**RESPONSE TO COMMENTS:**

**2/23/21**

**Permit Application Number: 2001-170**

**9027 SE 60th. St.  
Mercer Island, Wa. 98040**

**1** SCALE 1/2" = 1'-0"

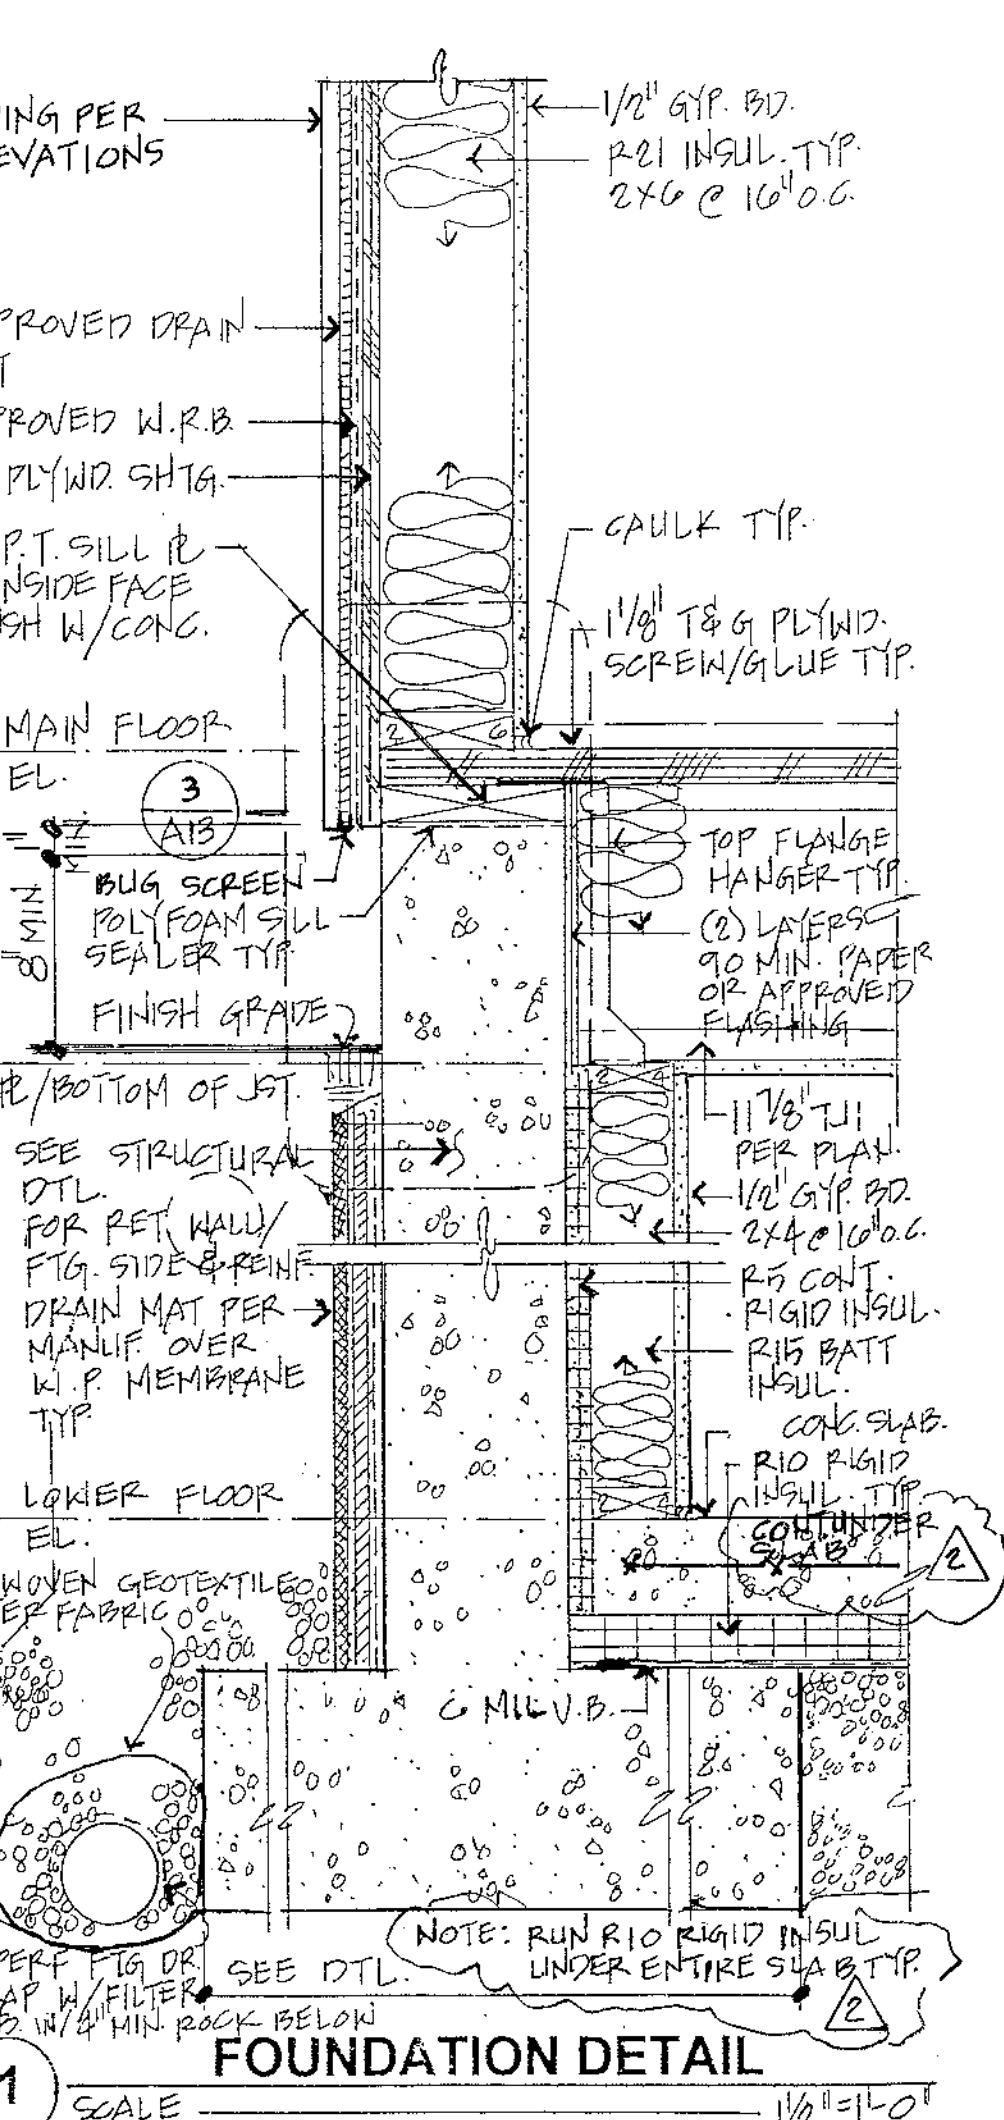
Page 17:  
Number 1: Added detail 1/A8  
Number 2: Added note to detail 1/A13, also shown on sections AA, BB, & CC  
Number 3: Added note to detail 1/A13, also shown on sections AA, BB, & CC

**Number 6: Added to detail 1/A13 and sections AA, BB, & CC**

**M1**

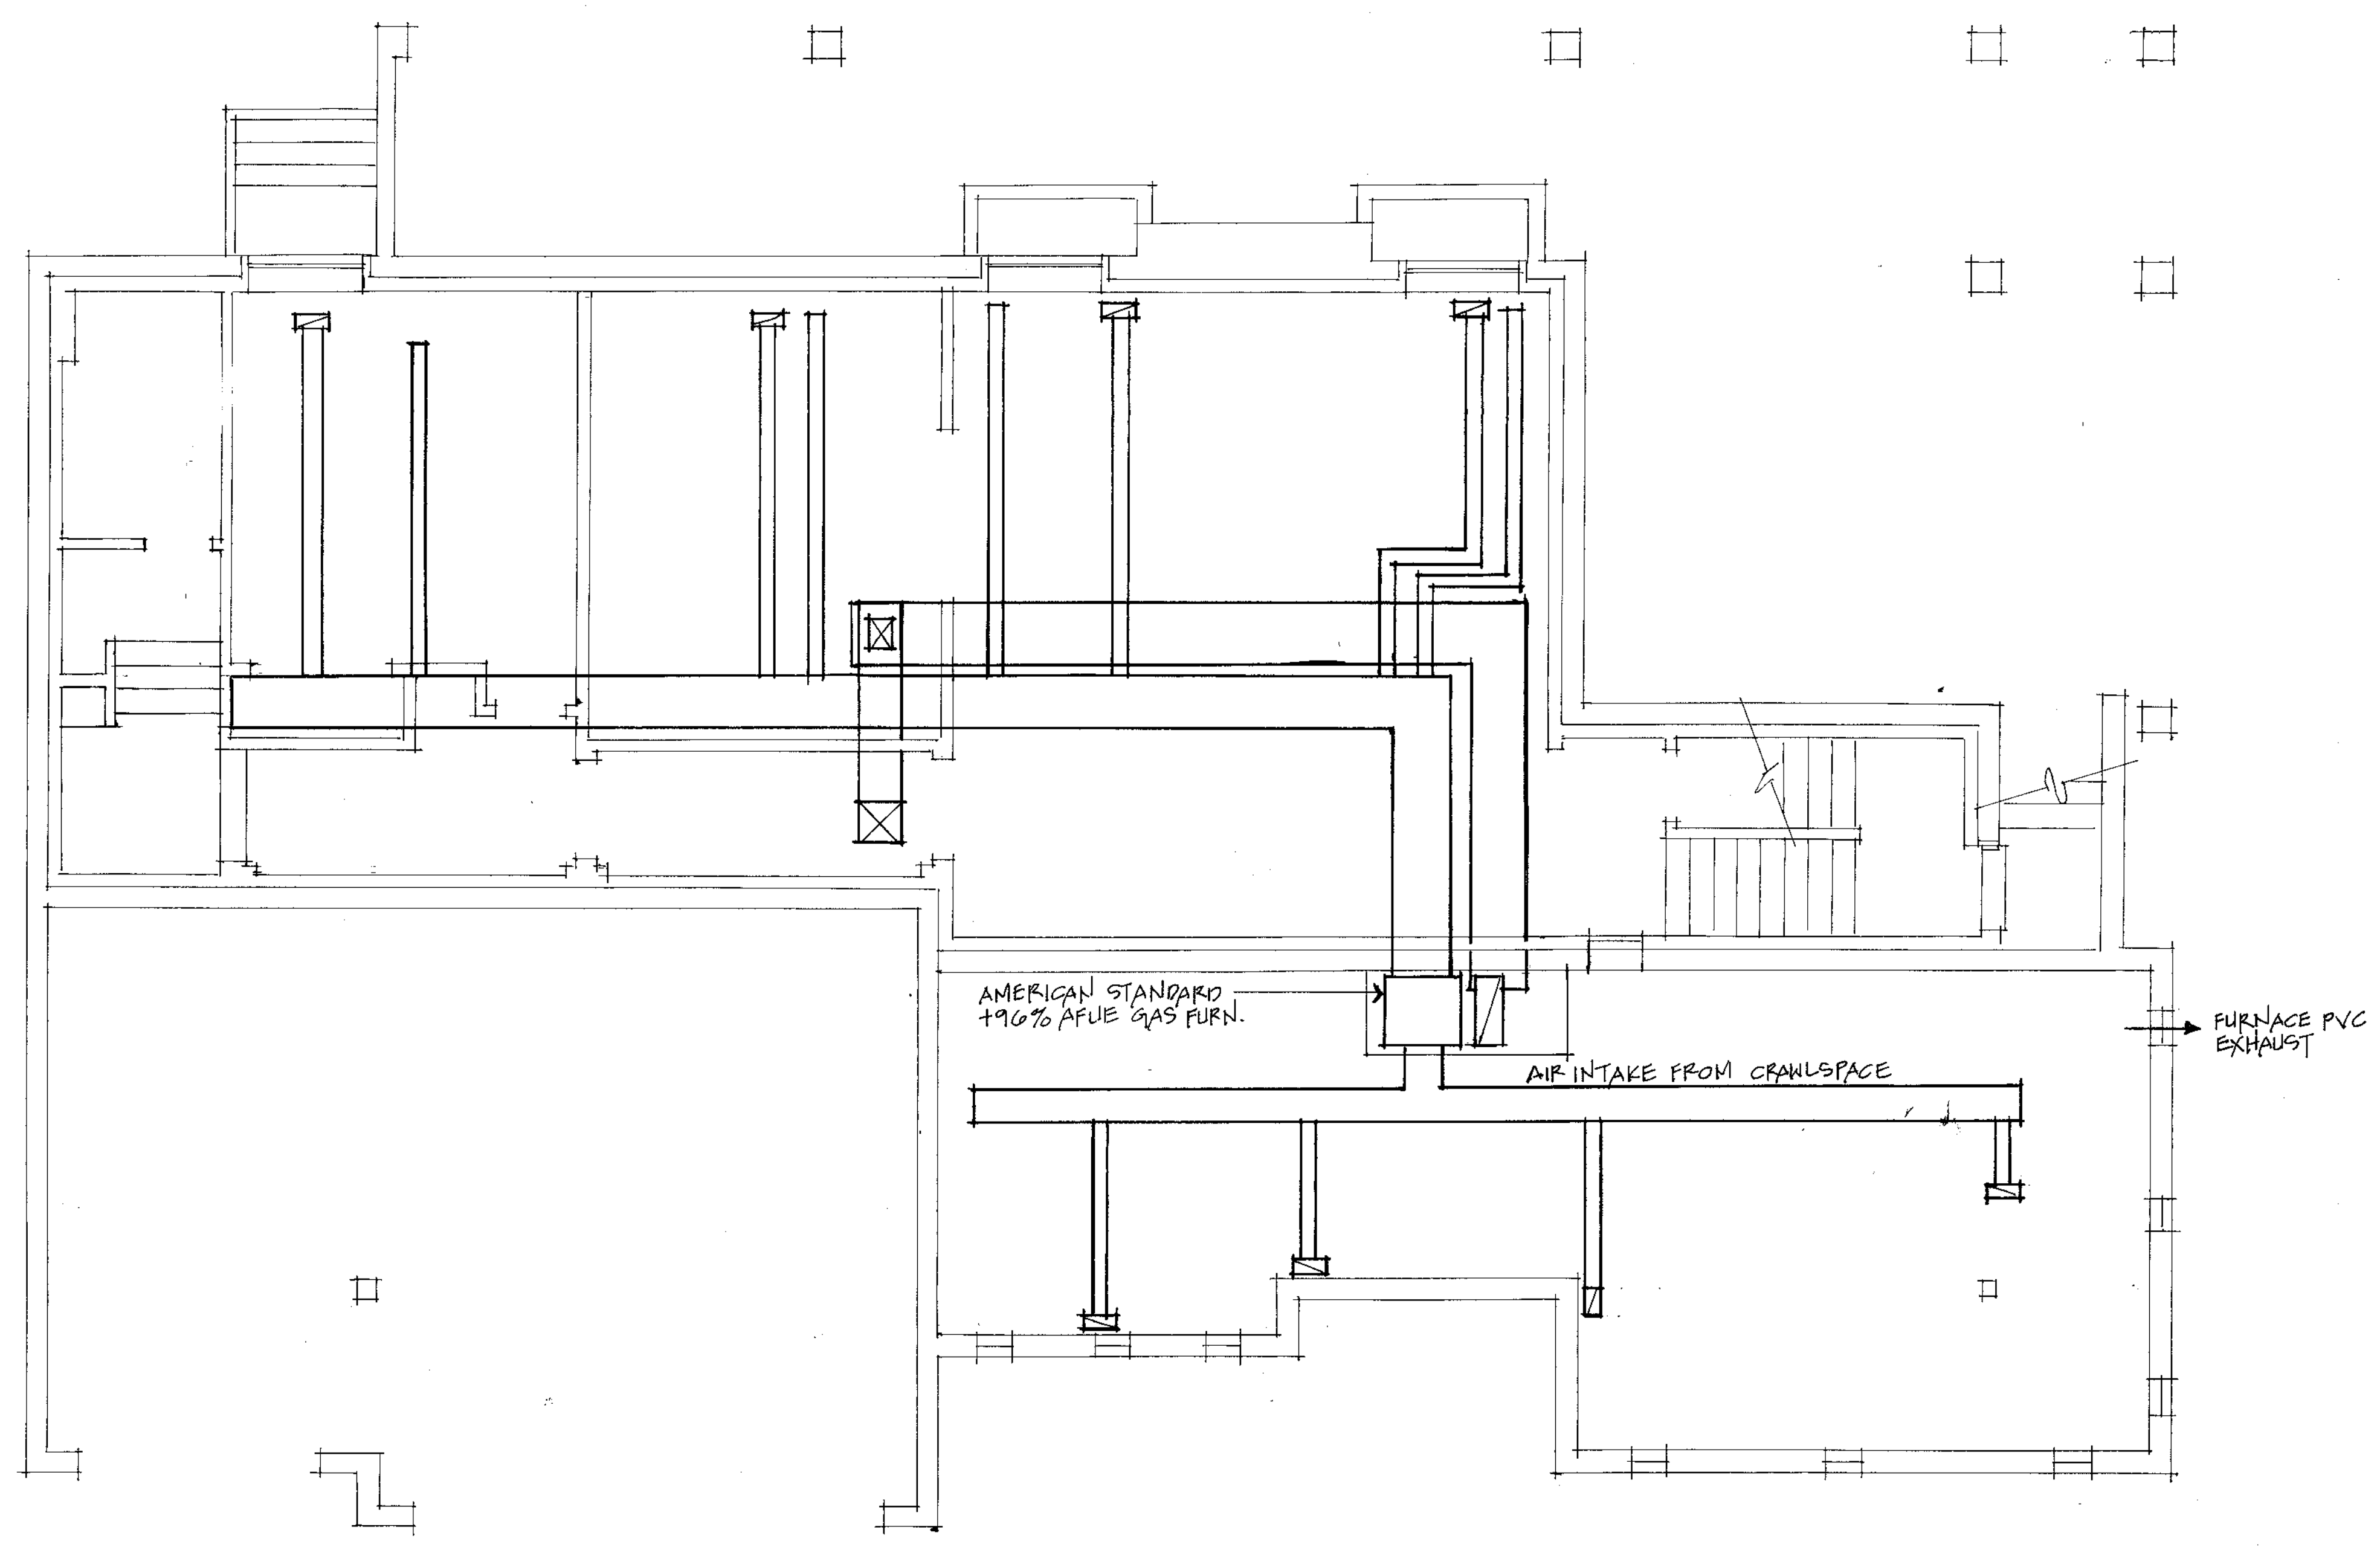
**Number 1: Added Sheet M1 indicating duct layout**
